# Statement of Response to An Bord Pleanála's Notice of Pre-Application Consultation Opinion ABP Ref: ABP-305726-19

## Strategic Housing Development at Lissywollen, Athlone, County Westmeath

**Delphi Design  
Architecture + Planning**

**Alanna Roadbridge Developments Ltd**

Site Plan Post ABP Preplanning Consultation 2 - key updates

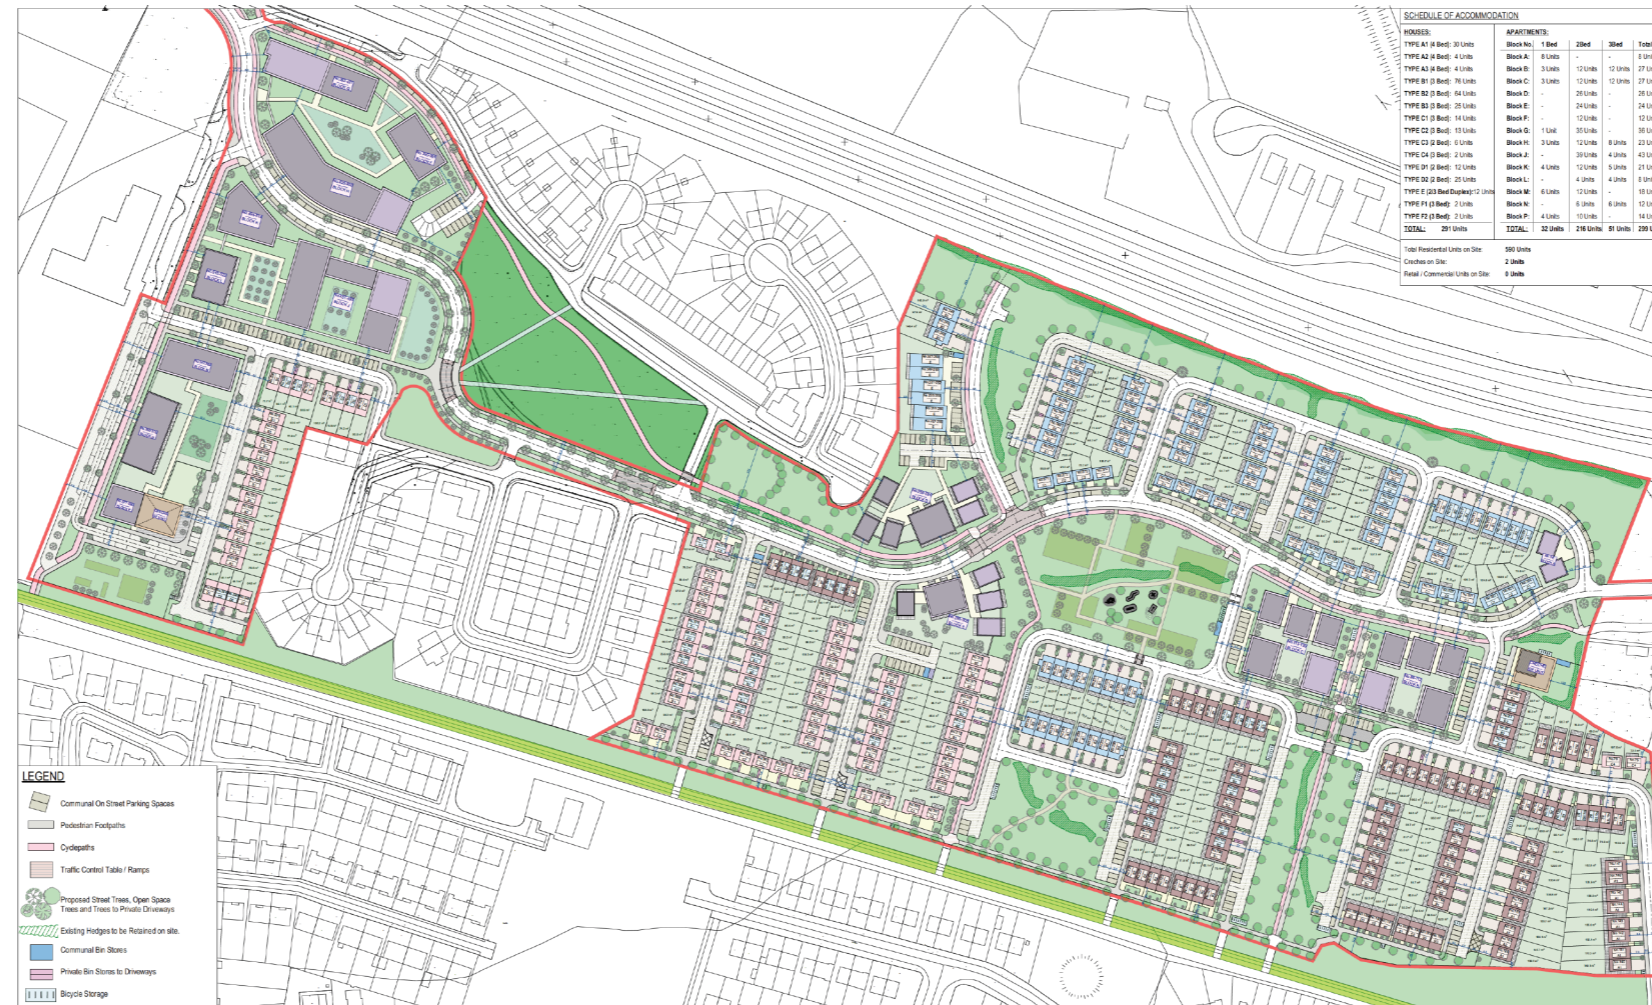
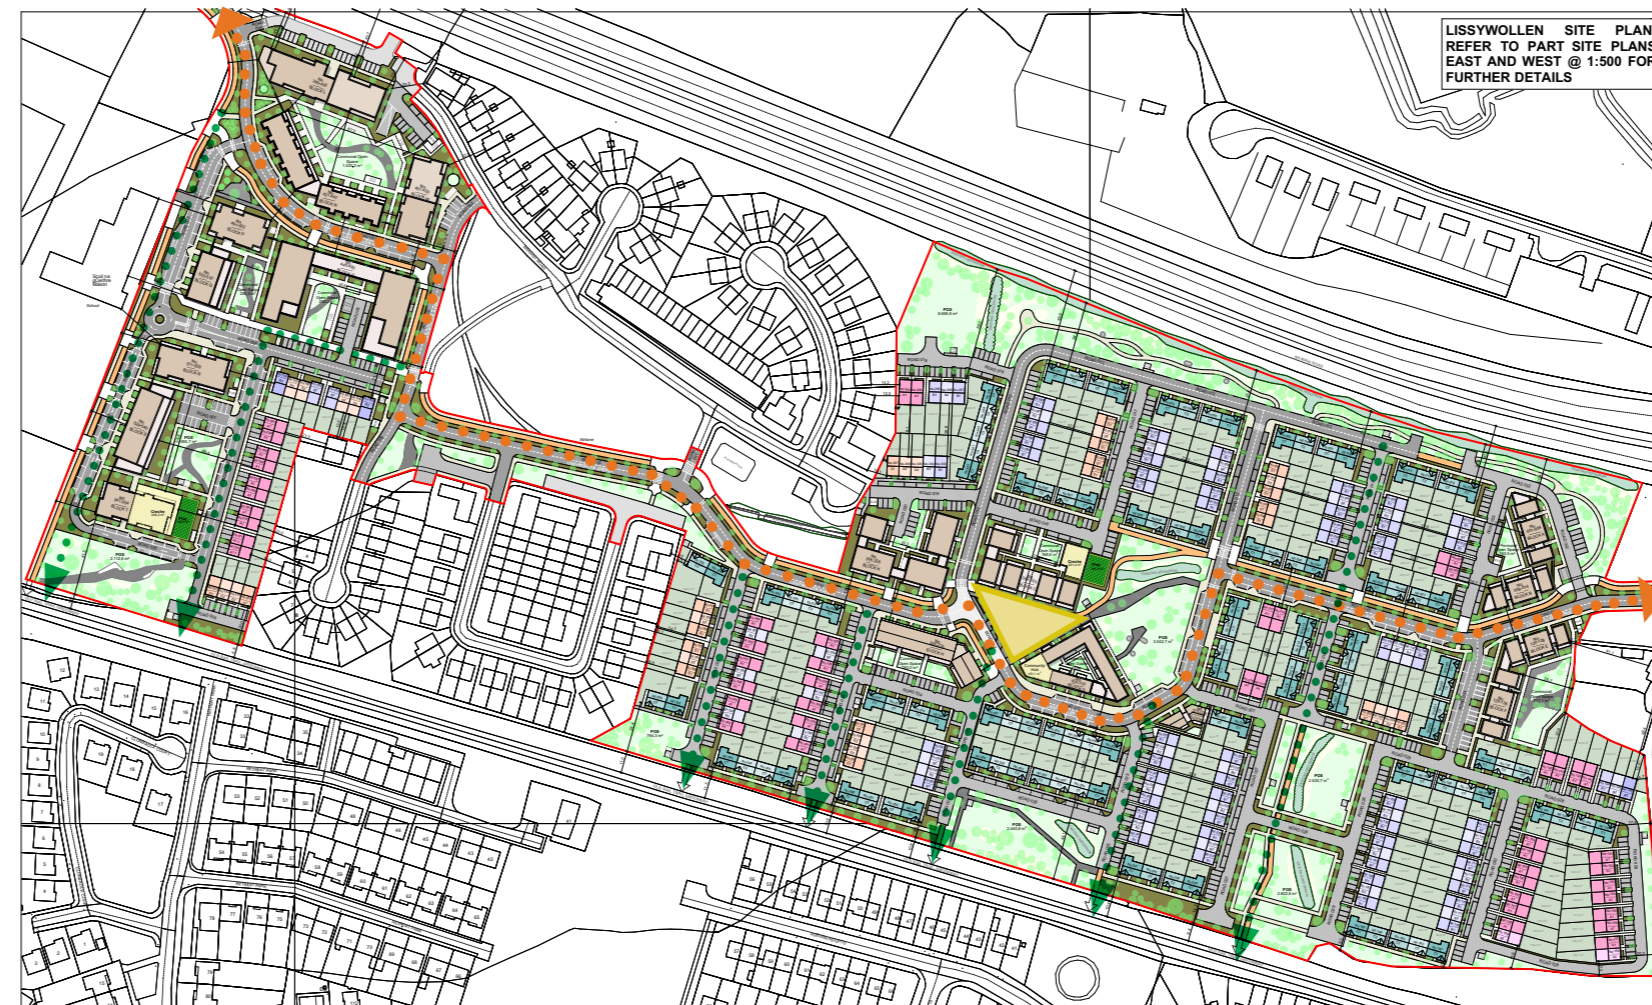
*“Further consideration/justification of the documents as they relate to the overall layout of the proposed development particularly in relation to the 12 criteria set out in the Urban Design Manual which accompanies the Guidelines for Planning Authorities on Sustainable Residential Development in Urban Areas, 2009, the Design Manual for Urban Roads and Streets, and compliance with the local policy document Lissywollen South Framework Plan. Specifically, further consideration/justification in relation to:*

**LISSYWOLLEN SITE PLAN**  
1:1000 @ A1

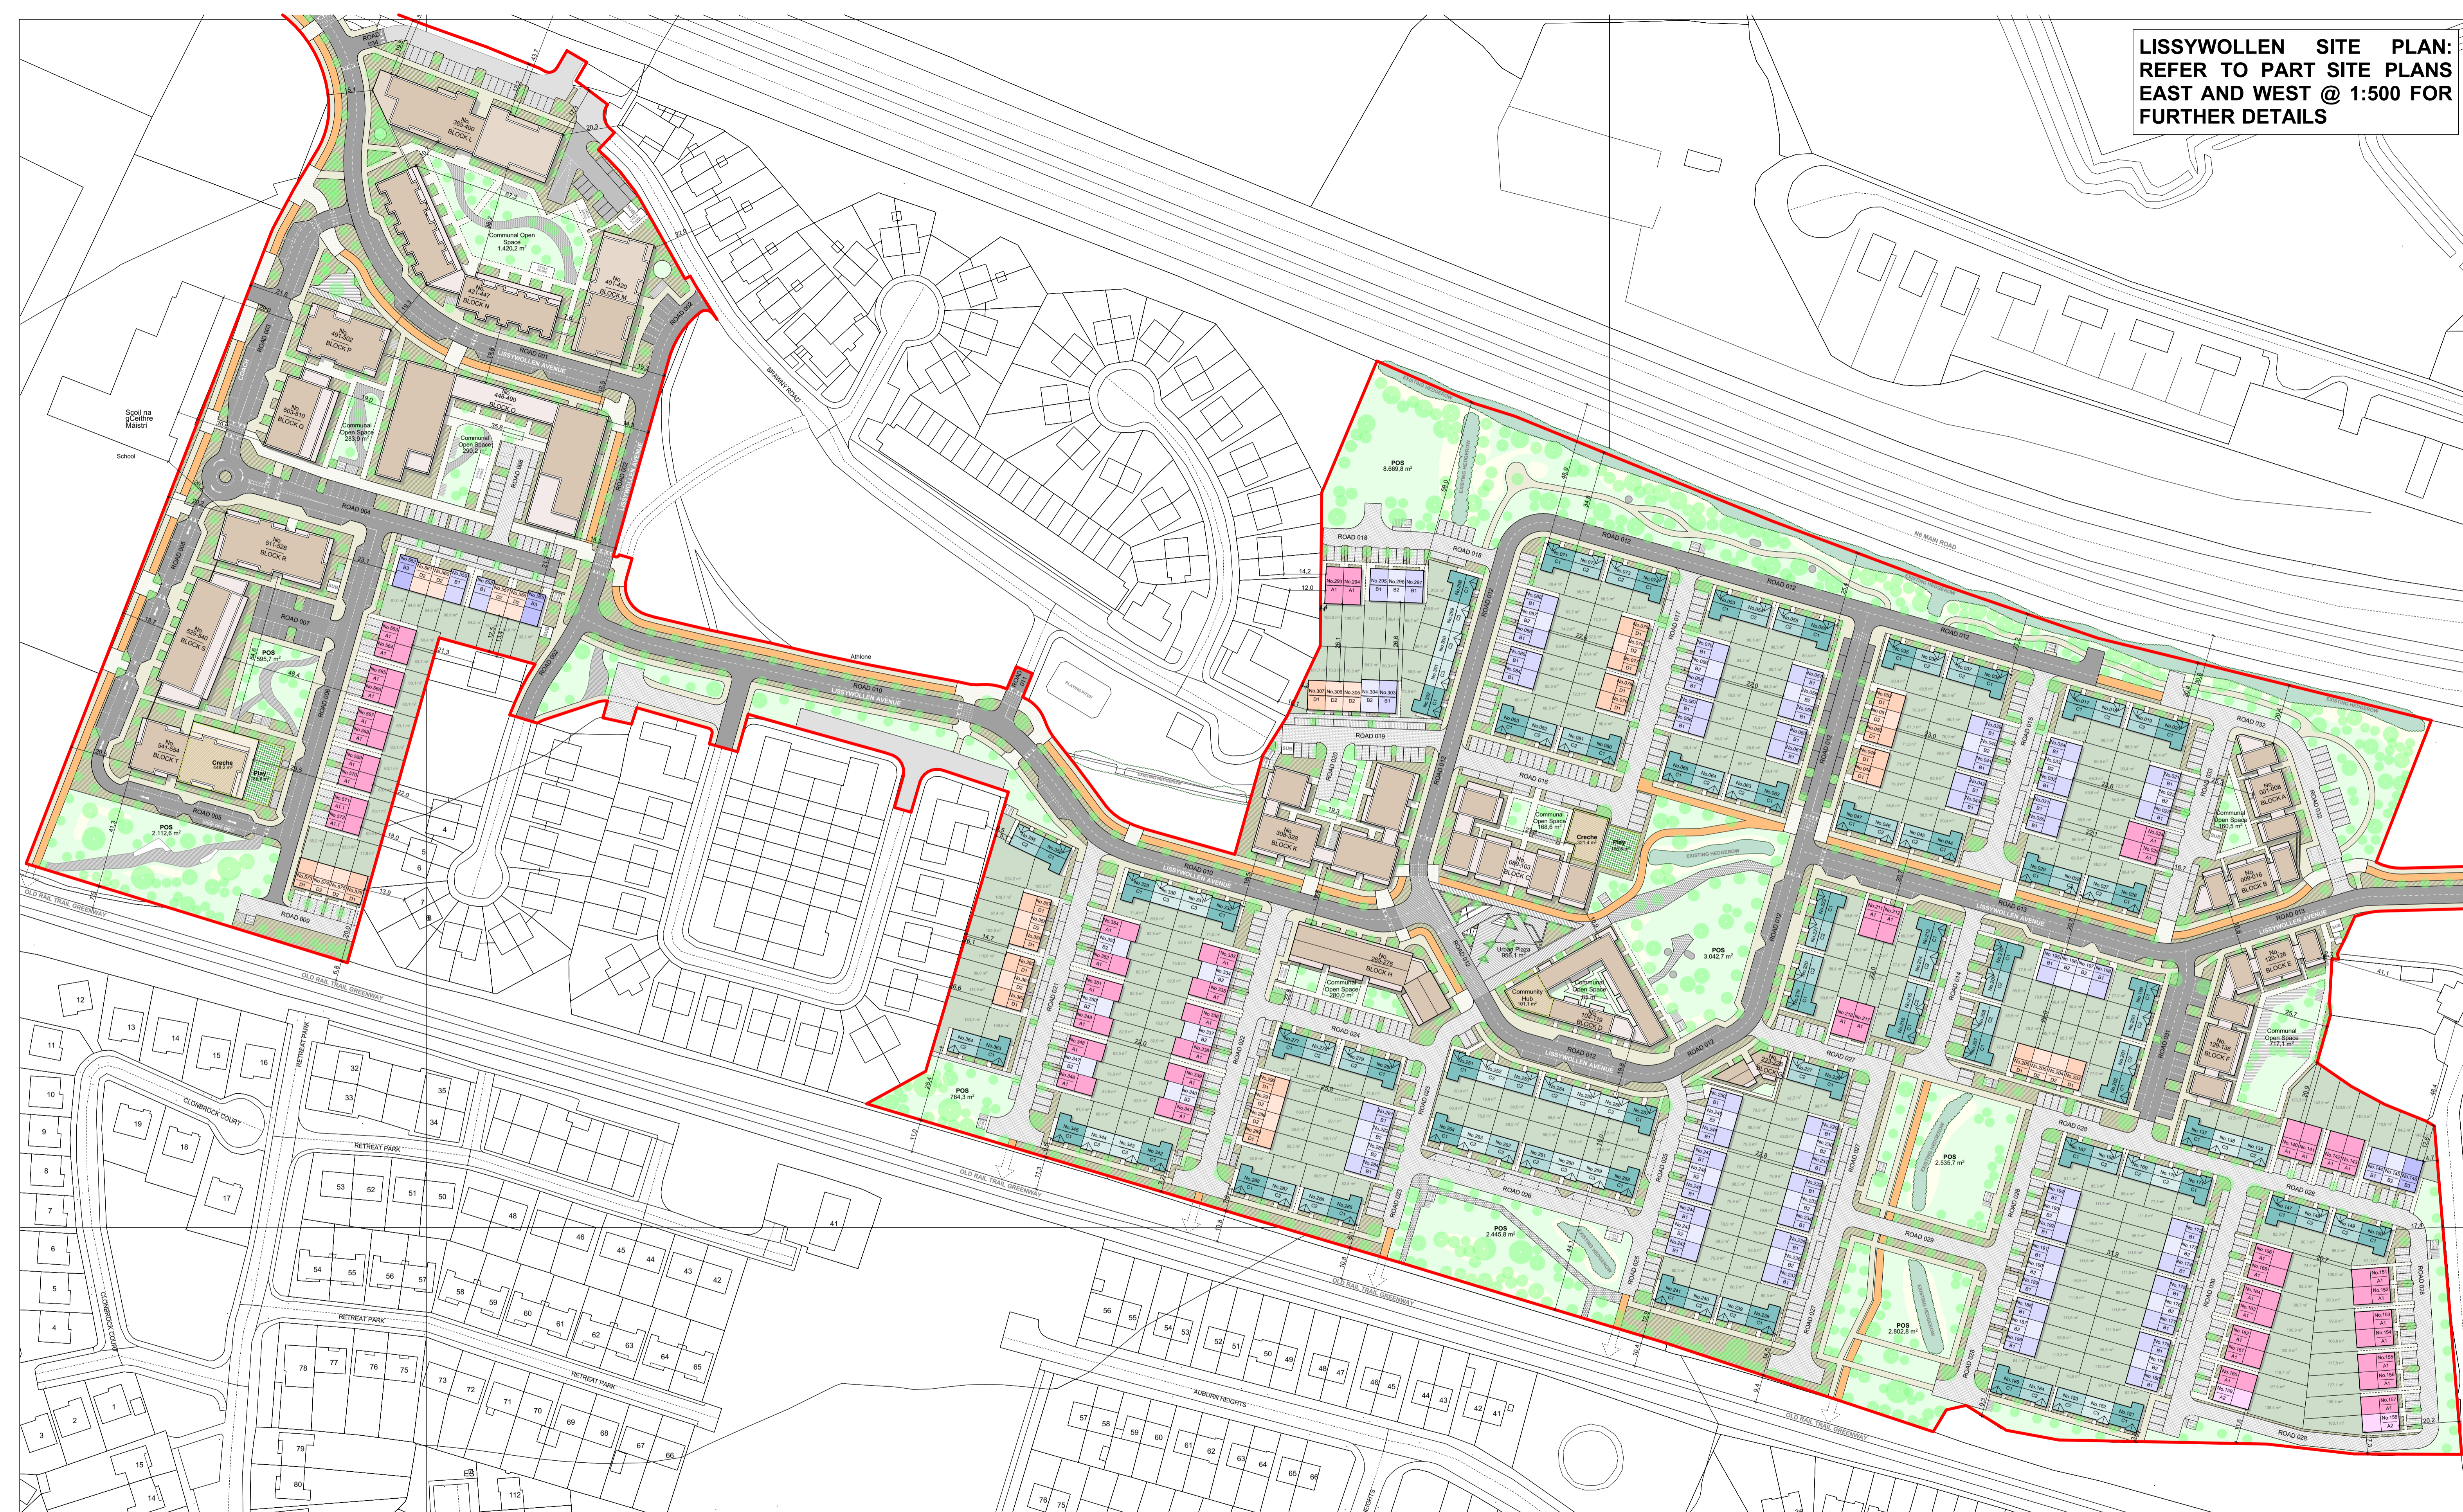
- (a) Site layout plan and design of the east-west link road/Lissywollen Avenue. This should be designed as a street and not as a distributor road, with an active and strong urban edge, and further consideration should be given across the development to achieving an appropriate level of enclosure of streets and open spaces (proposed and existing) through the built form, in addition to landscaping. This may involve a realignment of the east-west route, re-examination of the location and scale of the proposed central public open space, and re-examination of the layout of the building blocks relative to streets and open spaces.*

2.3.1 The proposed site layout plan has been considerably revised since the pre-planning consultations were held with An Bord Pleanála. Central to the layout revisions has been the design / route of the east-west link road / “Lissywollen Avenue” (hereafter the “avenue”) throughout the scheme.

2.3.2 The avenue has been realigned to cater for a more orthogonal layout with proposed dwellings repositioned to be closer to the avenue in order to achieve the appropriate level of enclosure of streets and open spaces. The scale of the central public open space has also been adjusted and the location altered in order to create more defined open spaces which are interconnected. It is considered that the layout now put forward for permission caters for an “avenue” which acts as a “street” that provides a sense of

- 2.3.10** As the avenue meets the existing public open space, a ‘T’ junction is provided (between Road No. 1 and Road No. 2 on the enclosed site layout plan prepared by Delphi Design which accompanies the application) and the avenue runs in a north-south direction along the existing public open space at Brawny. The avenue then turns to the east (at the junction between Road No. 2 & Road No. 10 on the enclosed site layout plan) and runs in an east-west direction along the existing public open space at Brawny. The rationale for the route of the avenue at this section of the scheme derived from several
